# Rezoning Transportation Analysis

Petition Number: 2020-119

Date	Description
09-11-2020	First Review (KP)
10-19-2020	Second Review (KP)

SHEET NUMBER
RZ-1

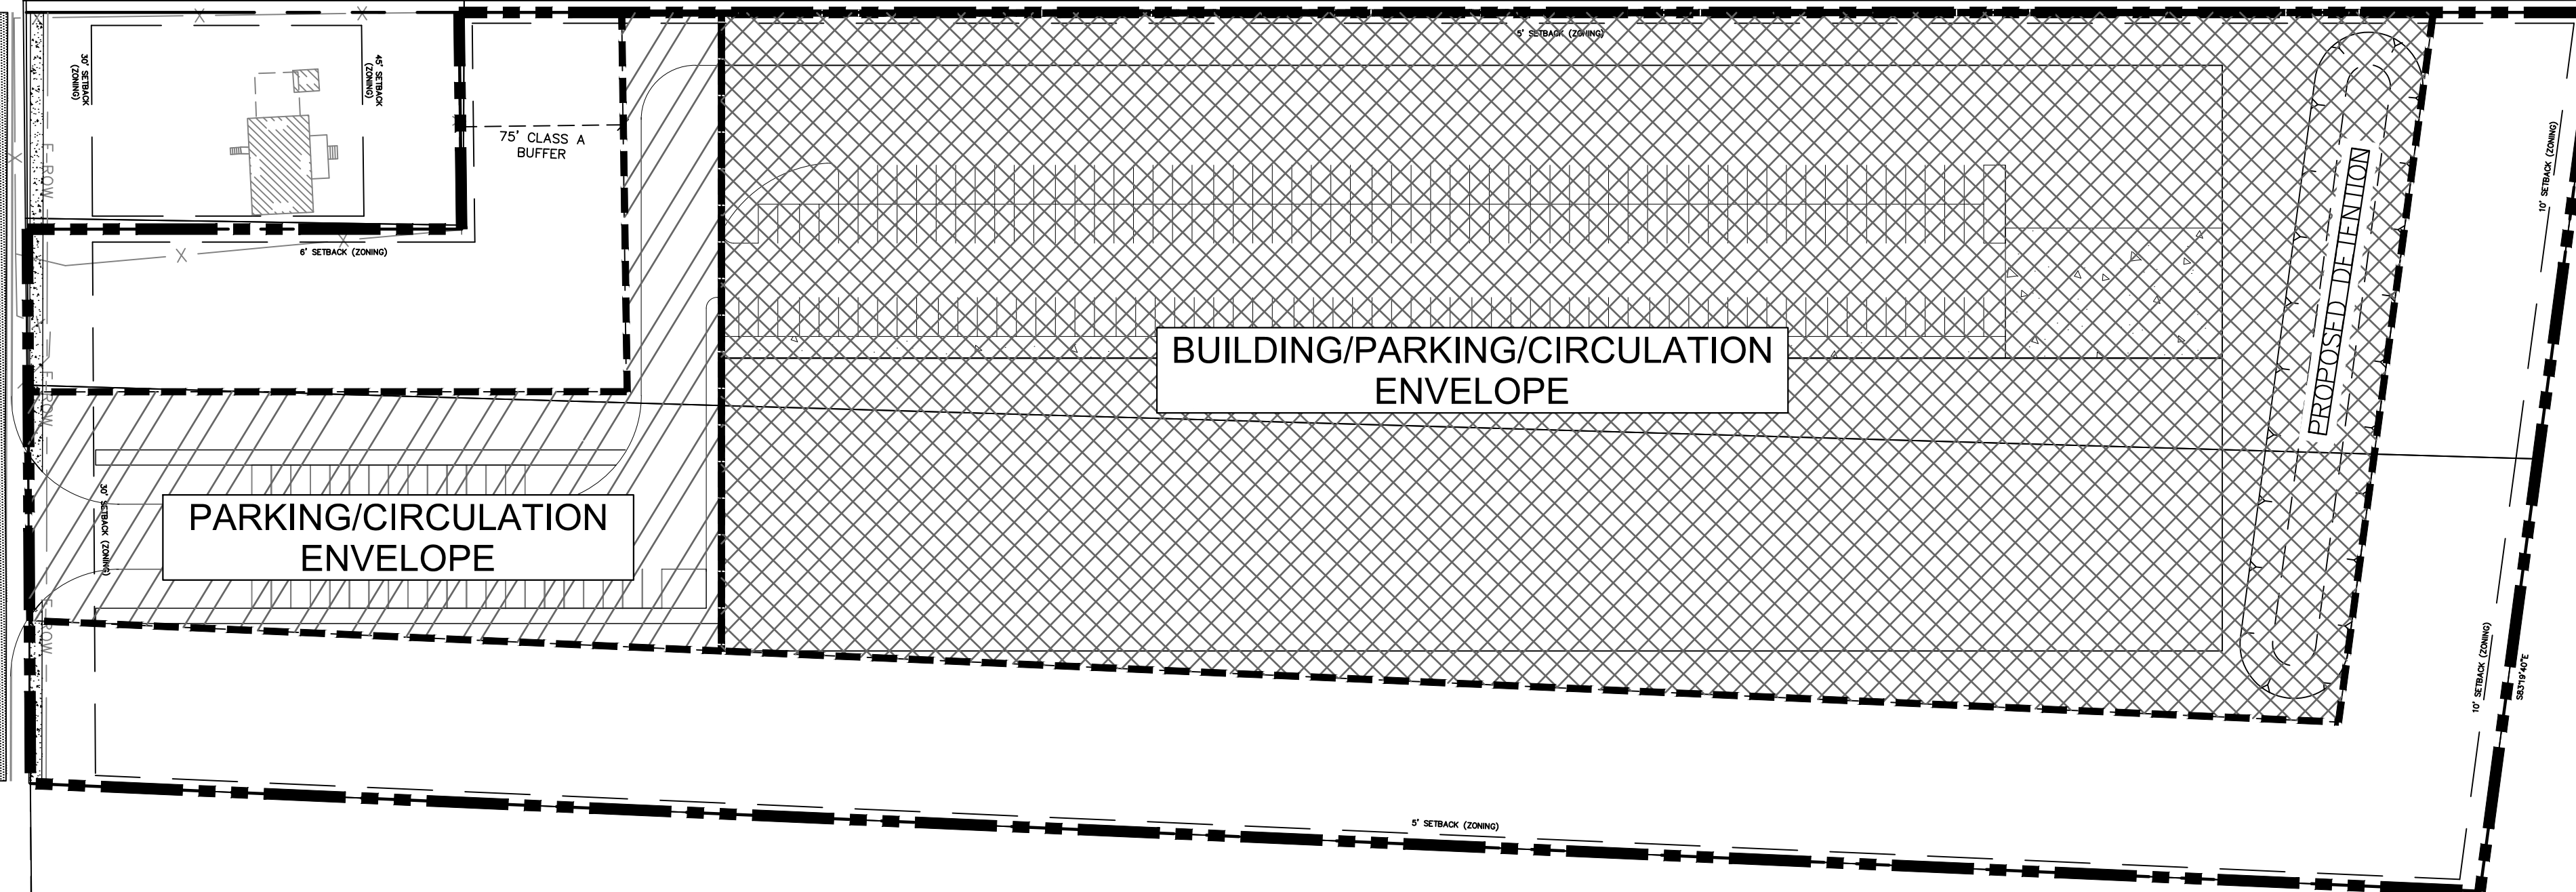
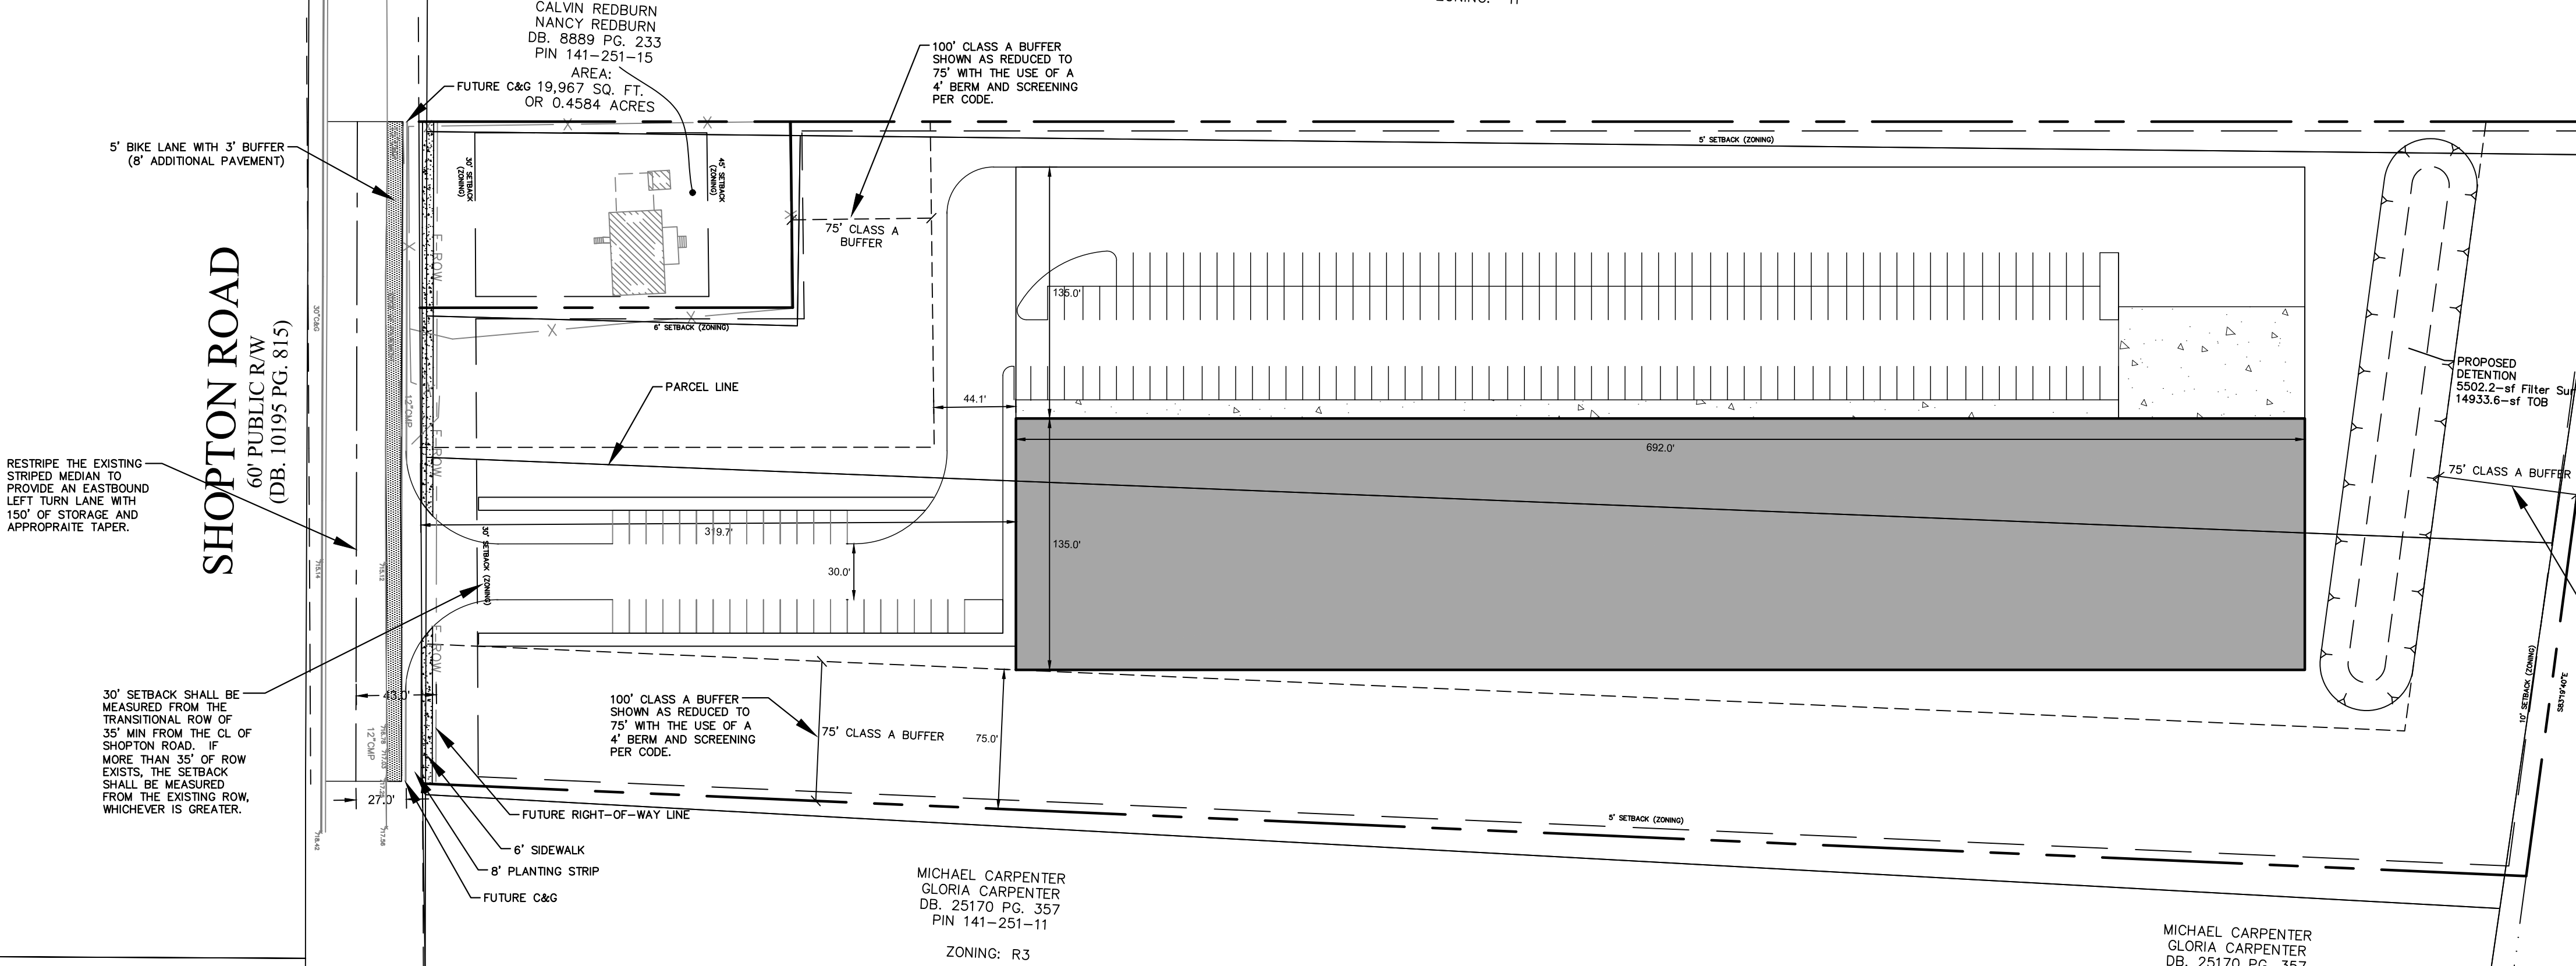
1. ~~**Curb Line** - Shopton Road: The future location of curb and gutter is located 27-foot from the centerline to back of curb.~~

~~The site plan needs the curb and gutter labeled and dimensioned from the centerline for each road.~~
2. **Traffic Study** A Traffic Impact Study is not necessary for the complete review of this petition. If during the permitting process the site generates more than 2,500 daily trips, then a traffic study will be required.

3. ~~Commit to dedicate 43-foot of right-of-way from the Shopton Road centerline, labeled and dimensioned from the road centerline.~~
4. ~~Revise the site plan and conditional note(s) to commit to construct an 8-foot planting strip, and 6-foot sidewalk on Shopton Road, as per City ordinance, labeled and dimensioned from the back of curb and gutter and road centerline.~~

5. ~~Revise the site plan and conditional note(s) to commit to construct a 5-foot bicycle lane with a 3-foot buffer along Shopton Road, labeled and dimensioned from the road centerline.~~

6. ~~Revise the site plan and conditional note(s) to commit to re-striping the existing striped median to encumber an eastbound left turn lane with 150-foot of storage and appropriate bay taper.~~

8. ~~Revise the site plan to add a note specifying dedication and fee simple conveyance of all rights of way to NCDOT before the site's first building certificate of occupancy is issued. CDOT requests right-of-way set at 2' behind back of sidewalk, where feasible.~~

9. ~~Revise the site plan to add a note specifying all transportation improvements will be approved and constructed before the site's first building certificate of occupancy is issued. The petitioner may phase transportation improvements if said improvements and phasing are explicitly described in site plan notes.~~

The site is located on Shopton Road, a state-maintained minor thoroughfare, approximately ¾ of a mile east of Steele Creek Road. As a part of this development, in-line with the City's WALKS and BIKES policies, the petitioner has agreed to construct an 8-foot planting strip and a 6-foot sidewalk as well as a 5-foot buffered bike lane along the site's Shopton Road frontage.

CDOT has no further comments associated with this petition.
